Comments from Greenspace

APPLICATION NO: A/9/19/PL

Site Address: Pound Place Roundstone Lane Angmering BN16 4AL

Description of Works: Demolition of existing dwelling & erection of a 62 bedroom care home (C2 Residential Institution) with car park, landscaped gardens & access from Roundstone Lane (resubmission following A/51/18/PL).

TREE PROTECTION PLAN

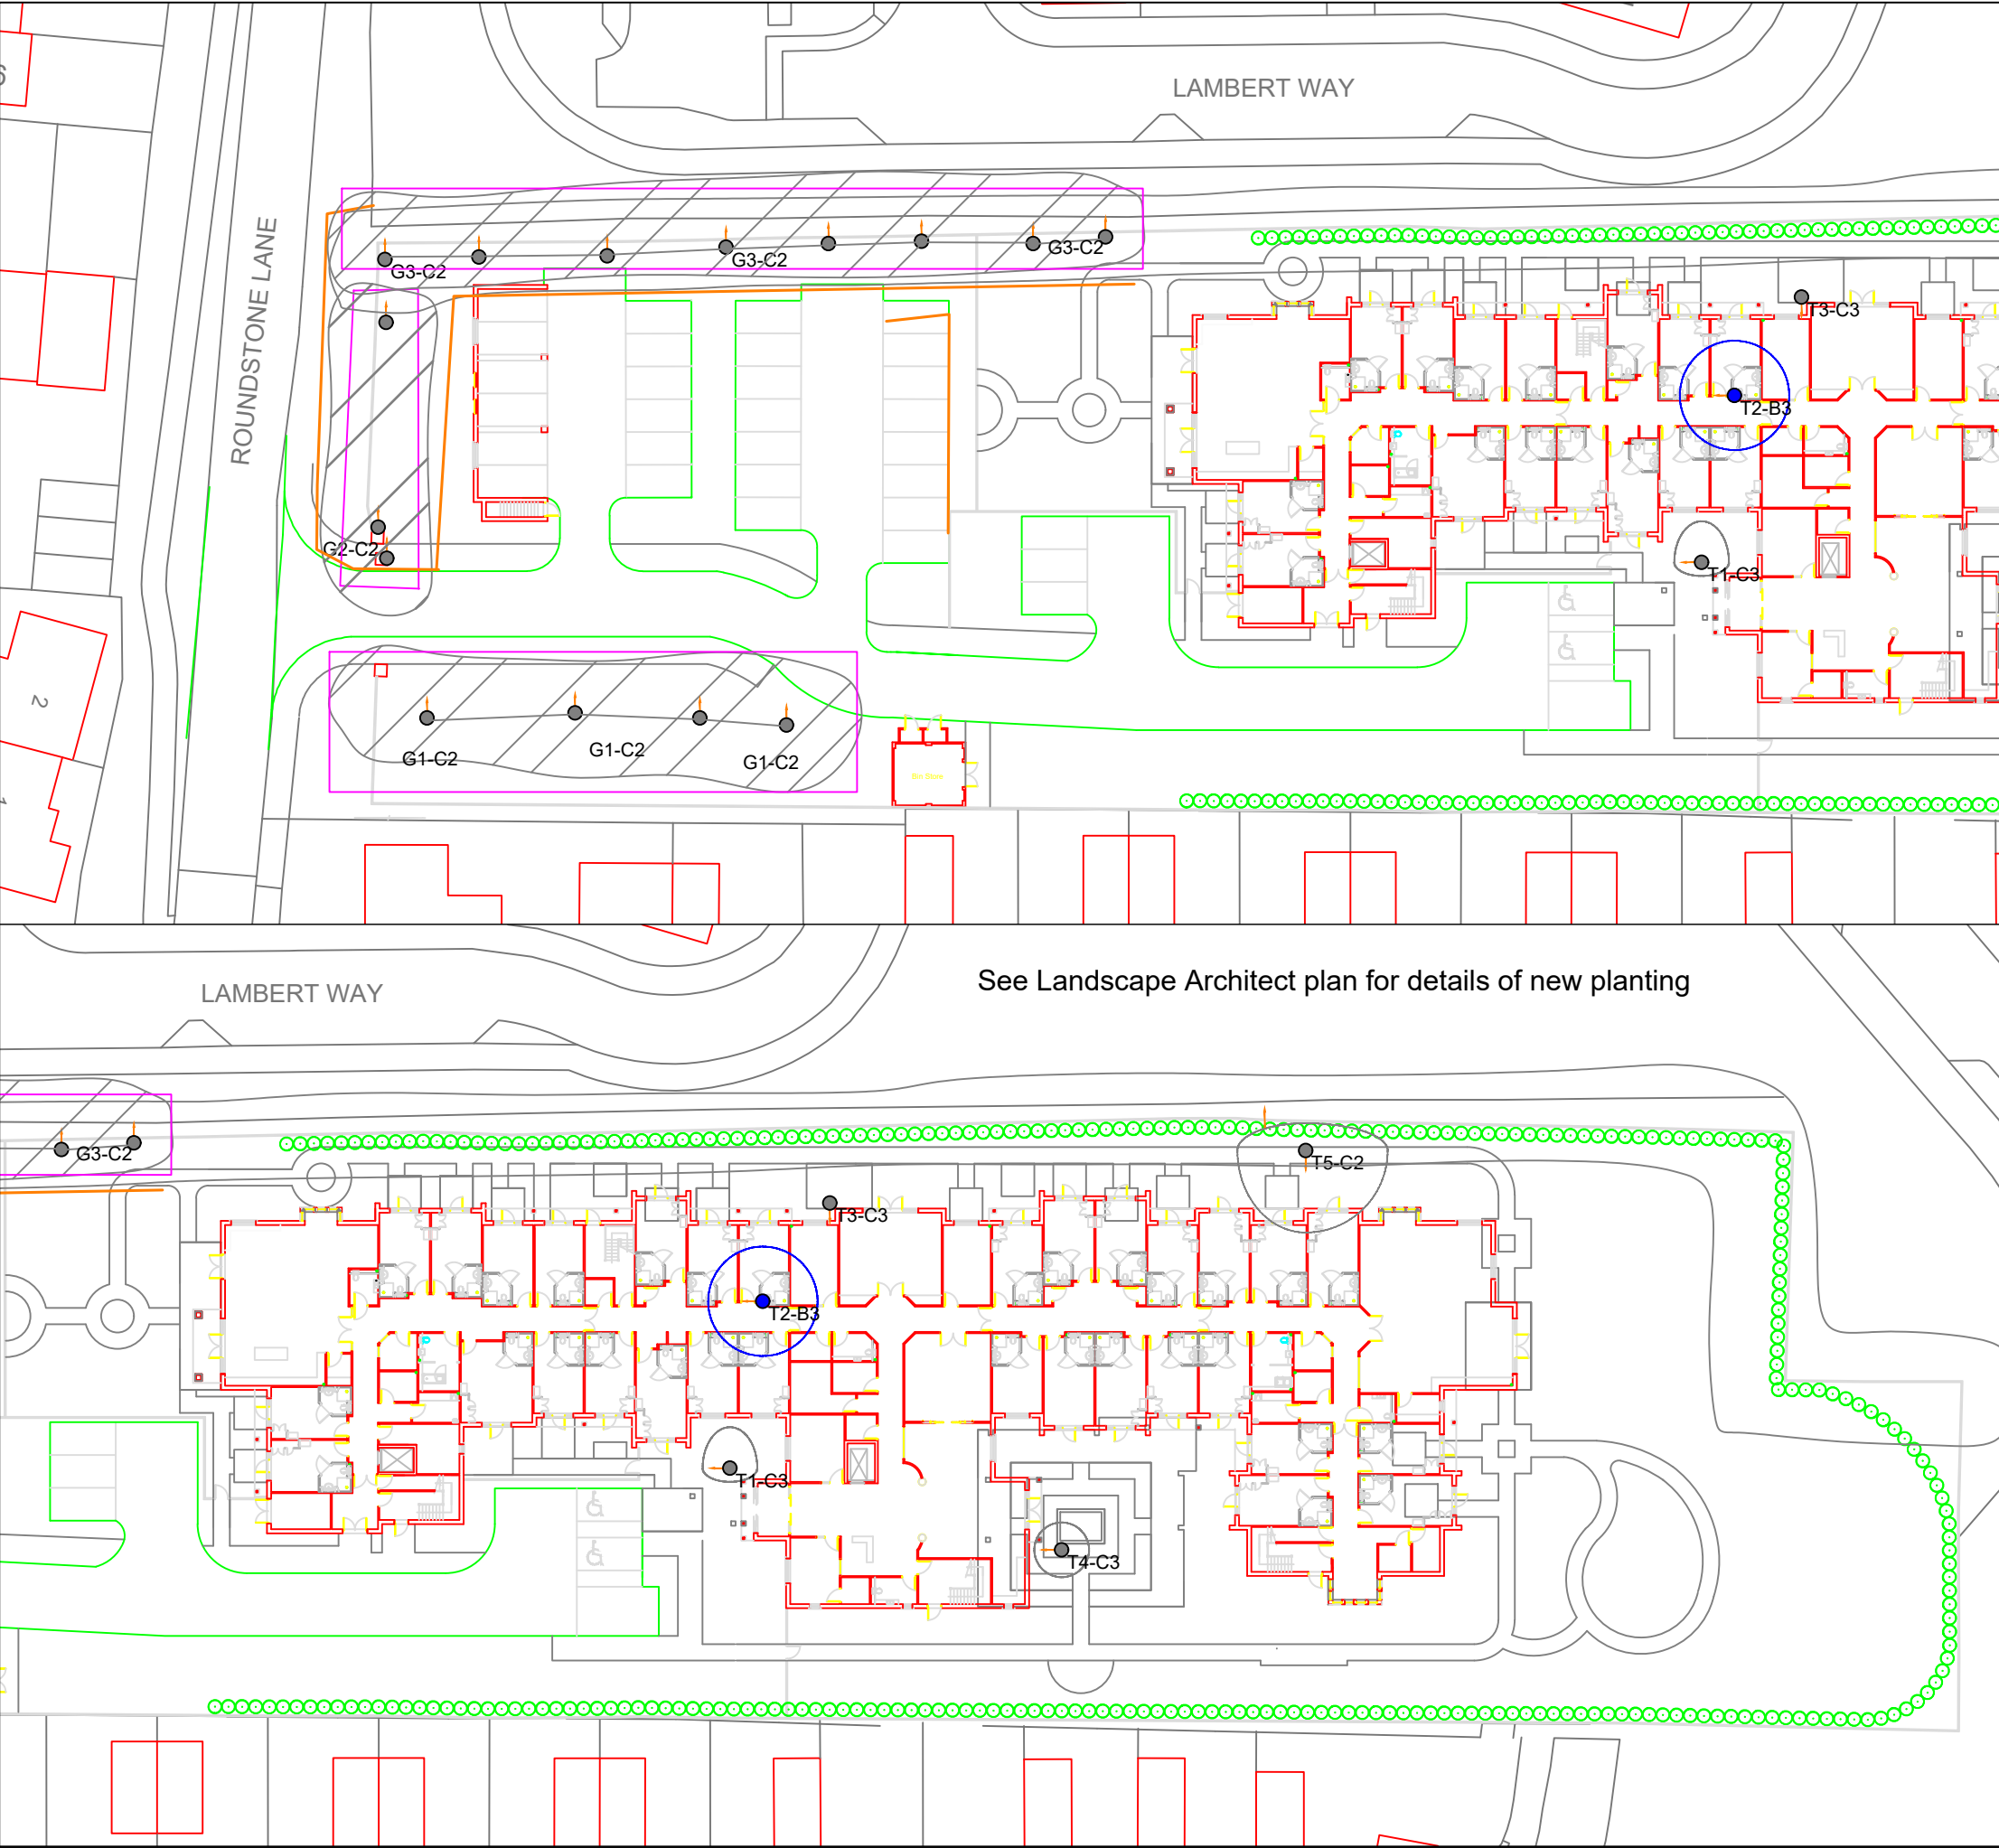
A comprehensive tree survey in accordance with BS5738 would need to be undertaken and tree protection fencing identified with the tree protection plan to be identified and applied to any permission. Any considered tree removal from this site should be agreed with Arun District Councils Tree Officer. Root protection Areas (RPA) should extend into the development site and to those in neighbouring land. Before construction, a tree protection scheme must be in place for any retained trees including trees whose root protection areas fall within the construction zone from neighbouring land. This should be in accordance with BS 5837:2012 'Trees in relation to construction' Any removed trees should be mitigated for allowing for inclusion of native species for biodiversity purposes and fitting to this setting.
